Application Ref:	3/2026/0154			 <p>Ribble Valley Borough Council www.ribblevalley.gov.uk</p>
Date Inspected:	16/4/26 (RVBC Environmental Health)	Site Notice:	25/3/26	
Officer:	BT			
DELEGATED ITEM FILE REPORT:				REFUSAL

Development Description:	Regularisation of construction of a steel portal framed building with associated chimney stack for use as a pet crematorium facility (sui generis).
Site Address/Location:	Dockber Laithe Farm, Sawley Old Brow, Sawley, BB7 4LF.

NORTH ELEVATION: POST-DEVELOPMENT

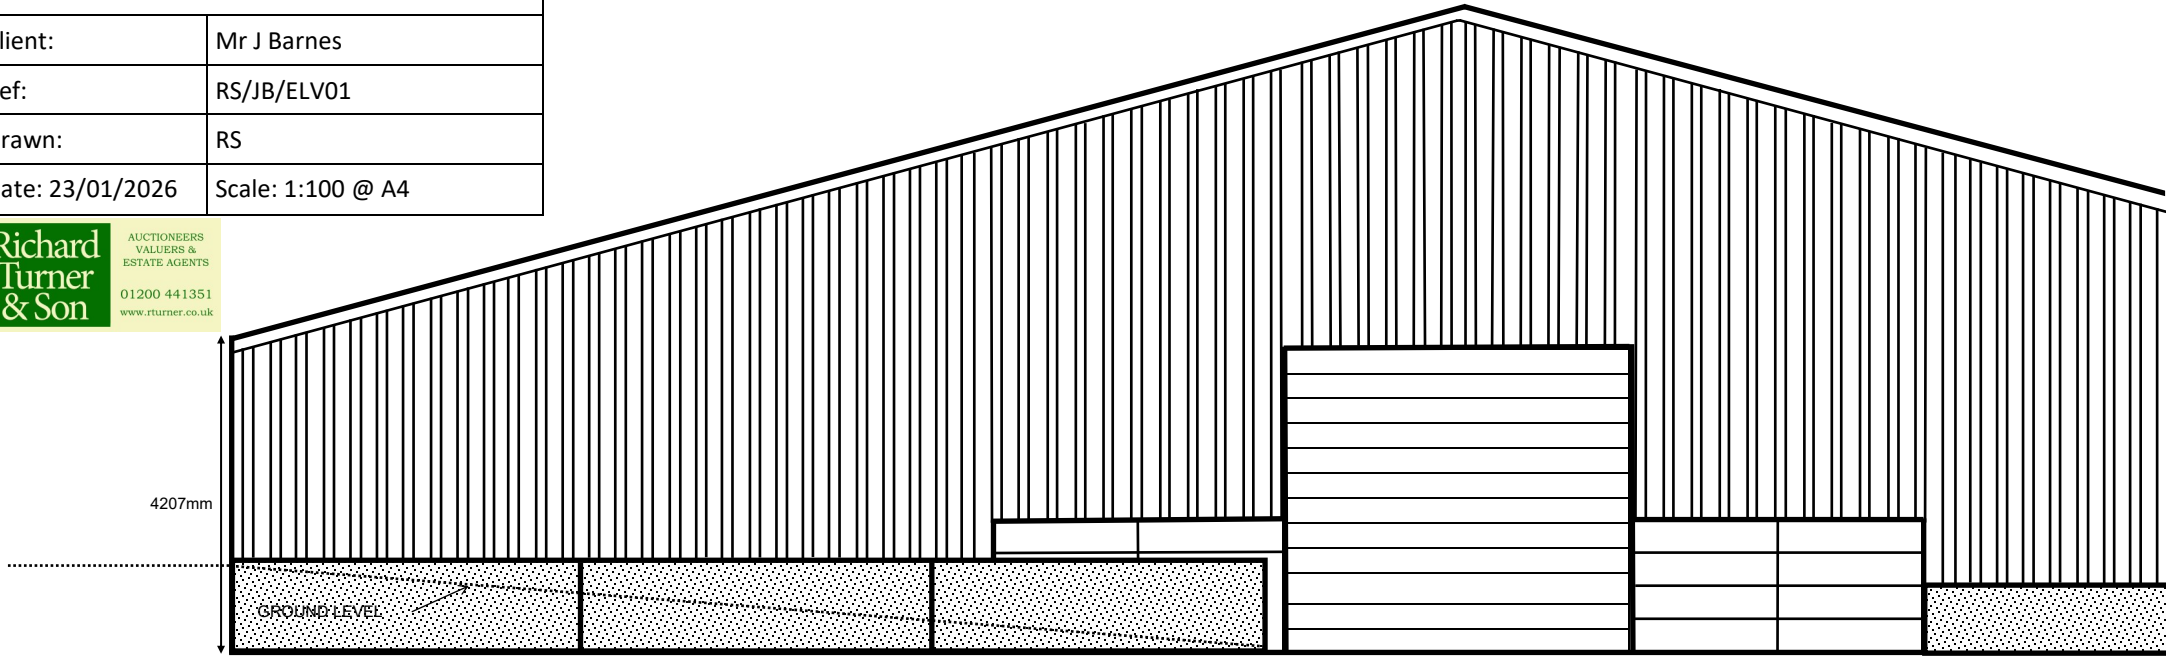
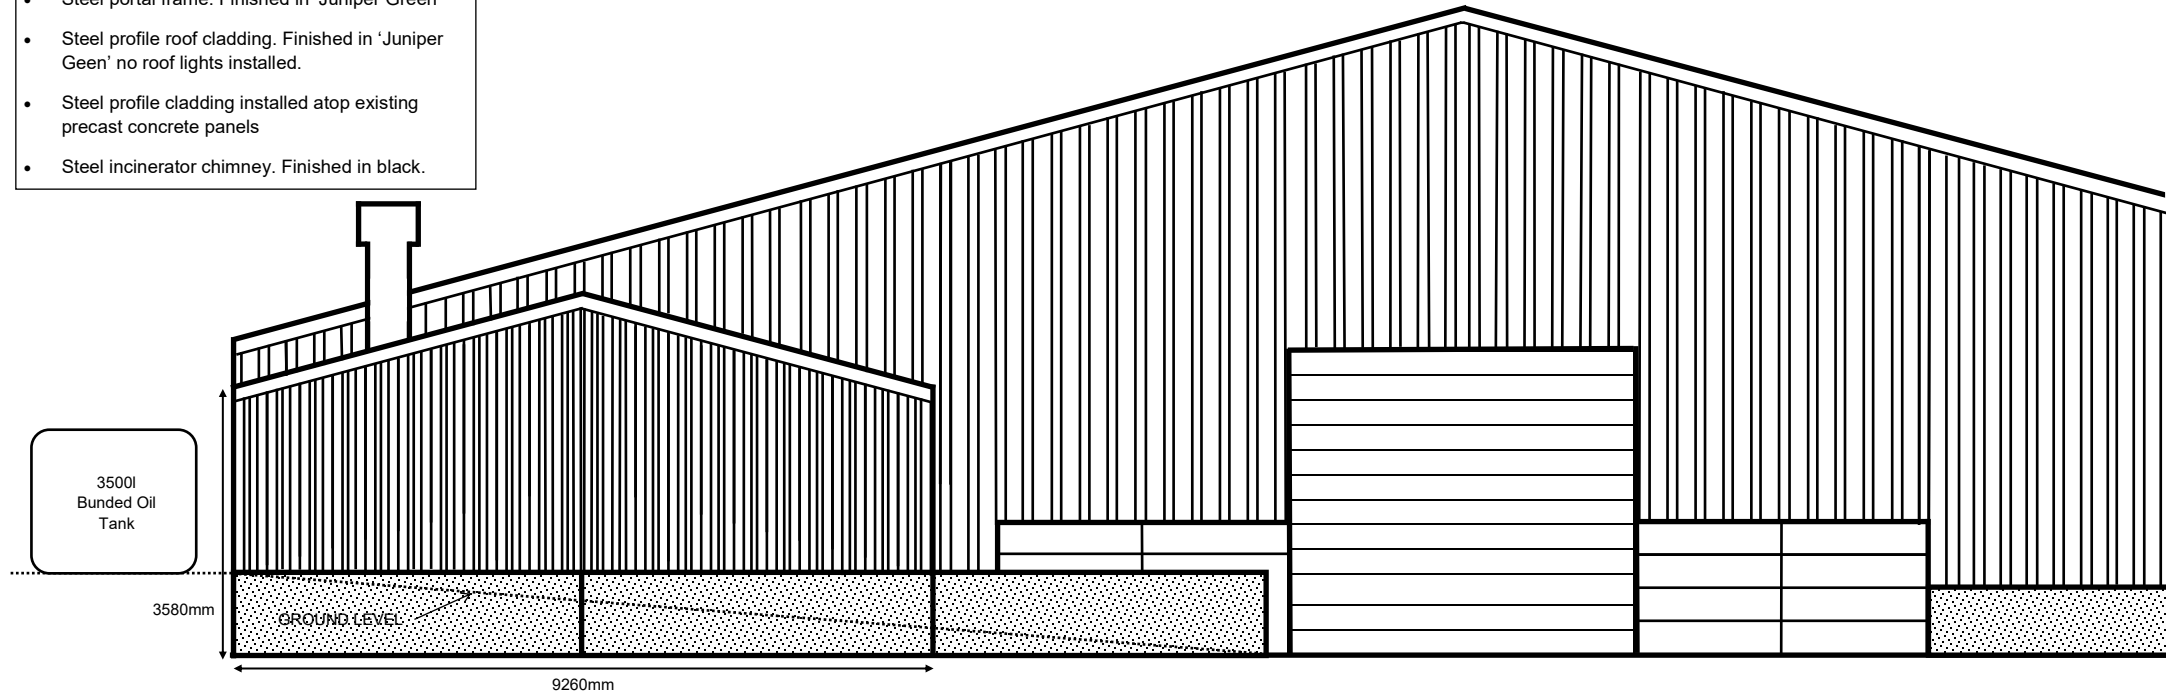
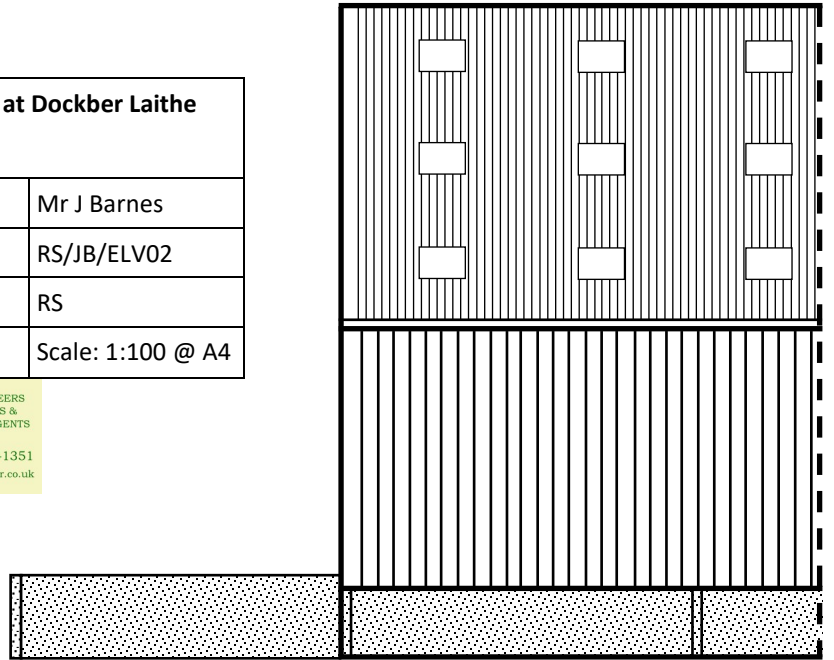
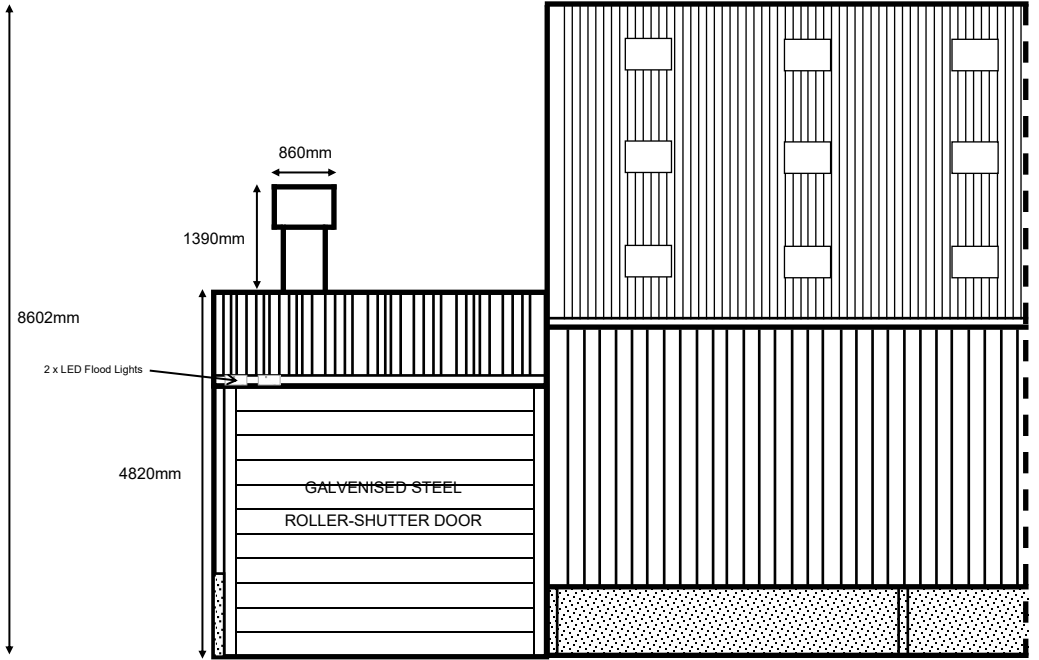
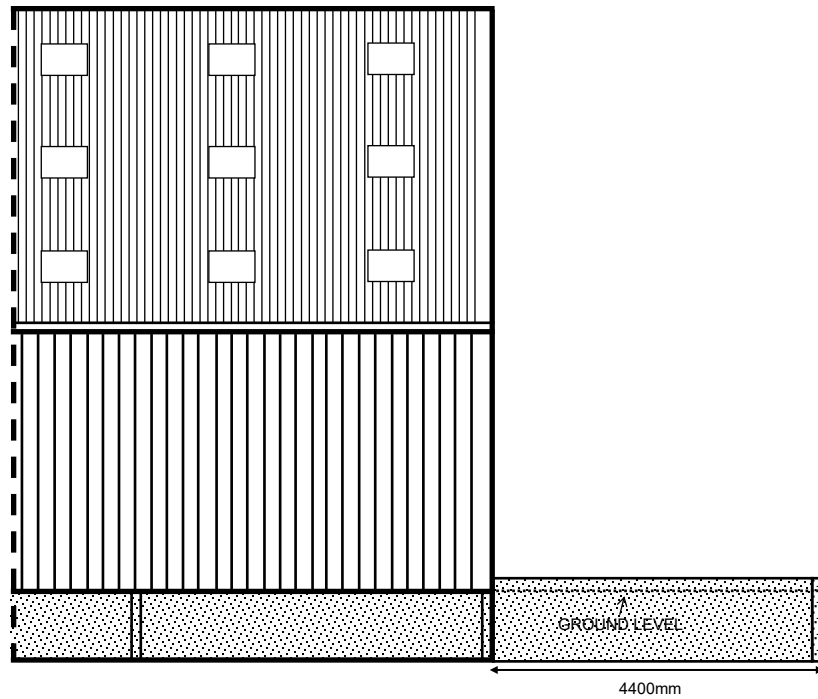
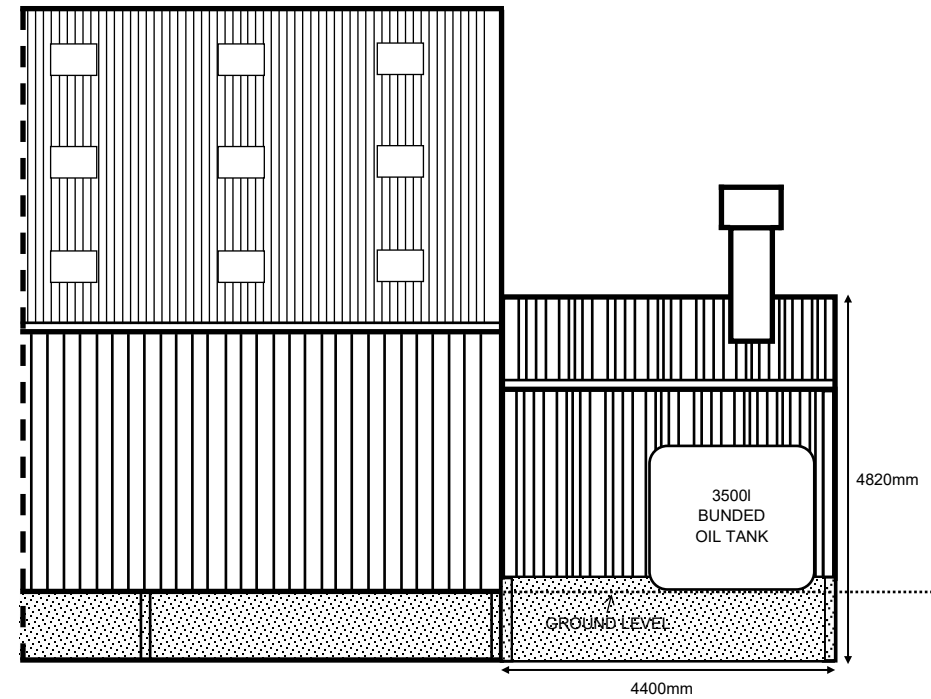
At present the application building retains the same design as proposed under previous application 3/2025/0517, albeit with the exception of a cowl feature which has since been added to the building's flue

which further reinforces the industrial character of the building. In addition, the application building remains visible within the public realm from Public Right Of Way BW0339020. As such, and as conveyed under previous application 3/2025/0517, it is considered that the unauthorised building, by virtue of its predominantly industrial character, reads as an incongruous form of development in the context of the site's agricultural character and open countryside setting.

The application's supporting information deems the design and visual impact of the building's flue / cowl feature as justifiable on the basis of the building's flue / cowl feature being consistent with other more substantial and imposing agricultural features within the farmstead however this is not apparent within the photographs provided in the application's supporting statement.

03:	The proposed development, specifically the erection of an industrial flue / cowl, is considered to introduce an alien feature which is not appropriate to the agricultural character of the surrounding landscape, failing to protect, conserve or enhance the landscape and character of the Forest of Bowland National Landscape, contrary to the requirements of Key Statement EN2 and Policies DMG1 and DMG2 of the Ribble Valley Core Strategy and Paragraphs 135 (C) and 189 of the NPPF.
